# FALCON HIGHLANDS SOUTH FILING NO. 1

SITUATED IN SECTION 12, TOWNSHIP 13 SOUTH, RANGE 65 WEST OF THE 6TH PRINCIPAL MERIDIAN,  
COUNTY OF EL PASO, STATE OF COLORADO

File Number:  
SF2418

SITUATED IN SECTION 12, TOWNSHIP 13 SOUTH, RANGE 65 WEST OF THE 6TH PRINCIPAL MERIDIAN,
COUNTY OF EL PASO, STATE OF COLORADO

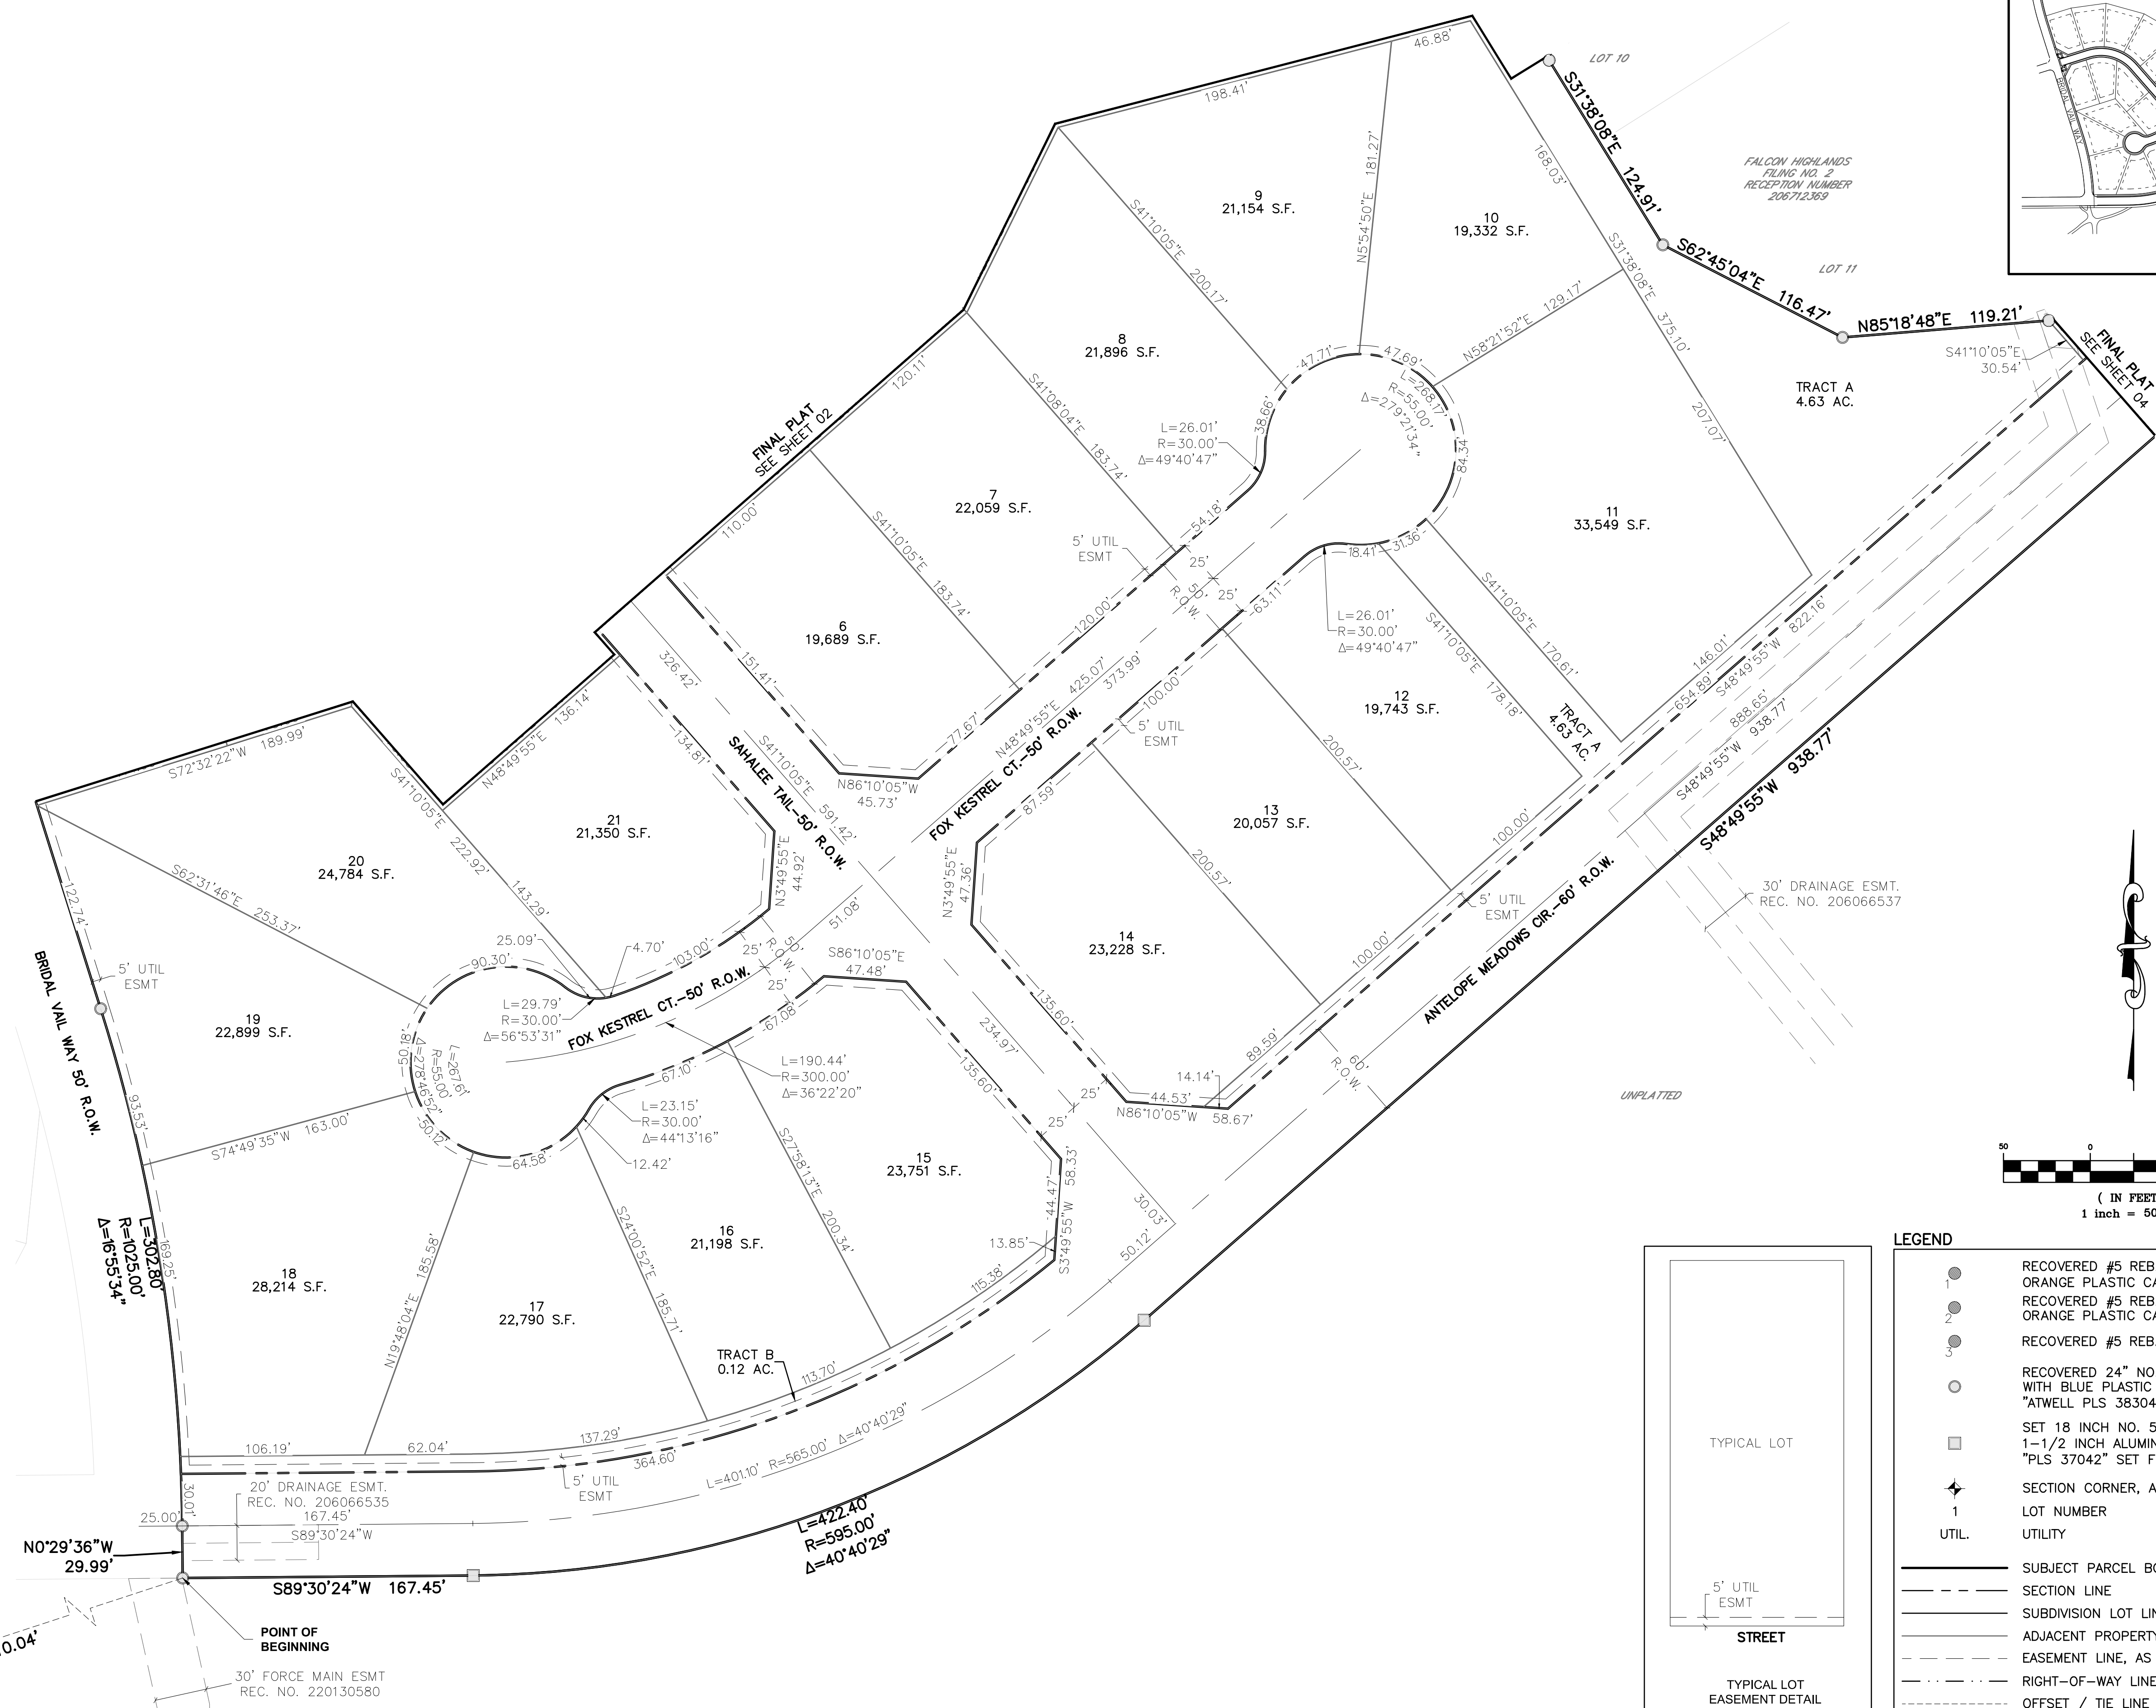
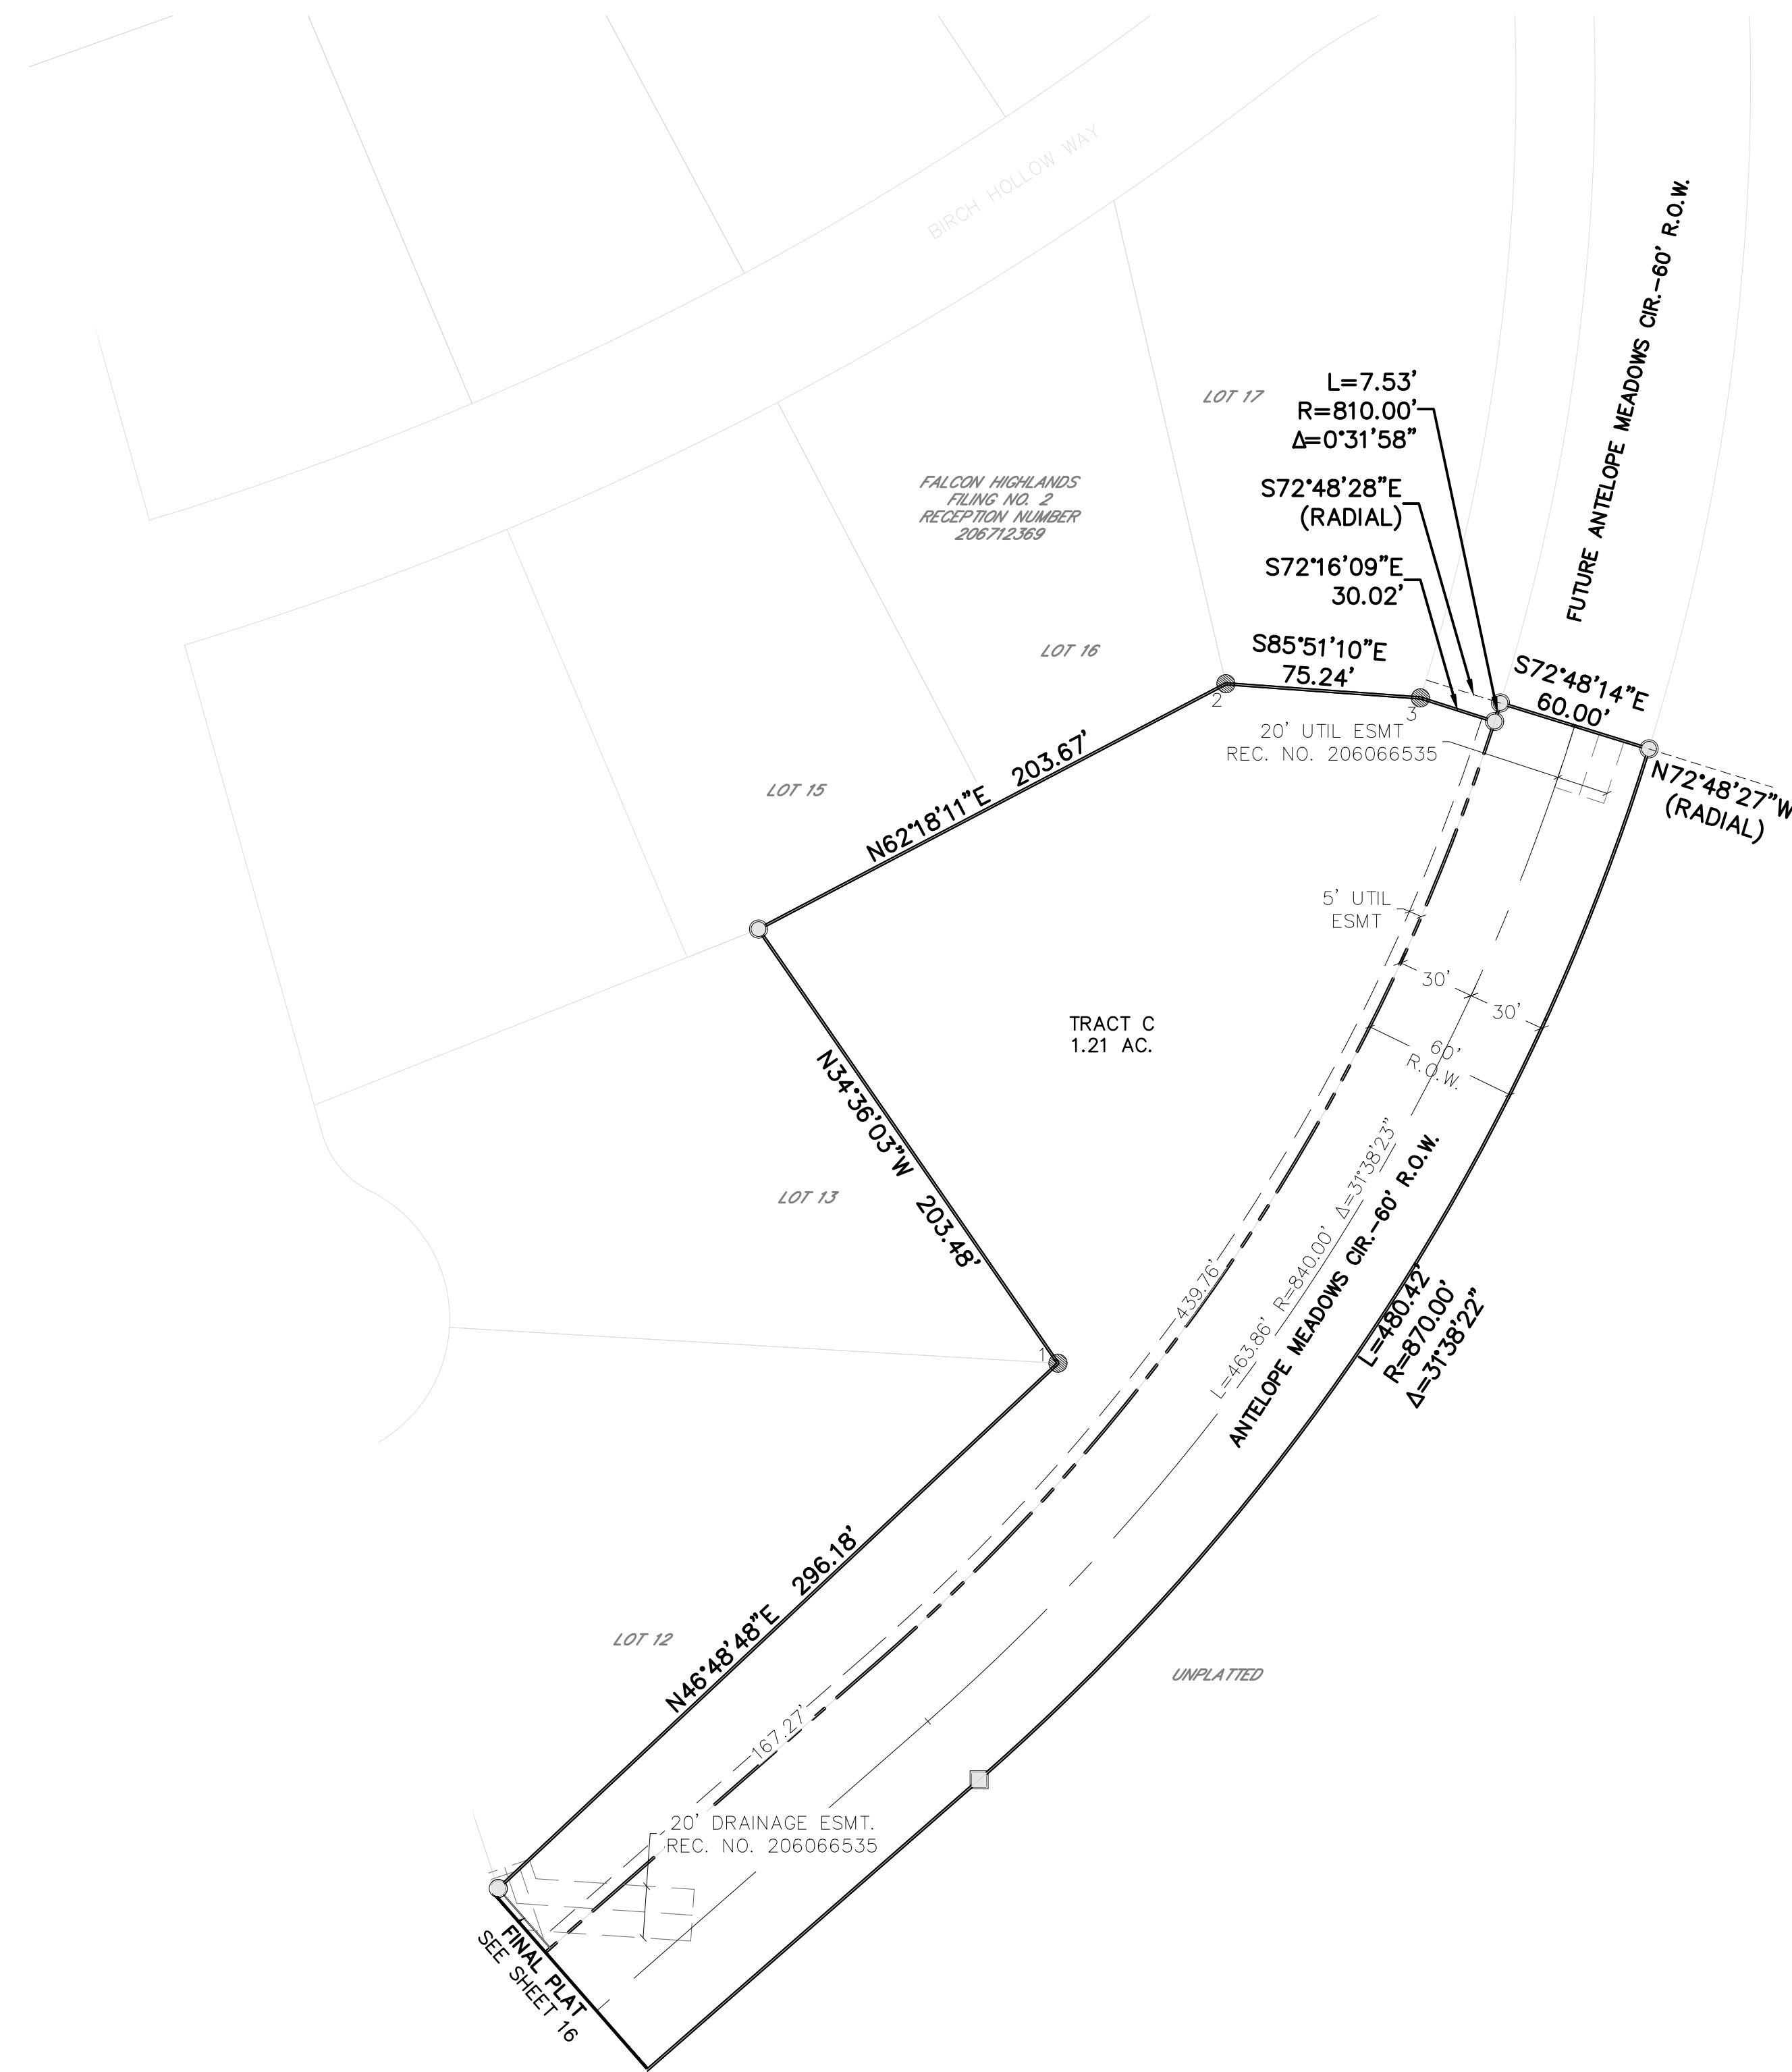
Lot sizes and configurations for this plat are different from PUD, please explain or adjust to match

This key map does not match what is being shown on this page of the plat, please adjust and show all easements on the lot (side and rear)

TYPICAL COMMENT FOR ALL EASEMENTS  
Please ensure that easements are shown properly.  
Also, please use this Plat as an opportunity to remove unneeded easements (such as locations where land will become EPC ROW)
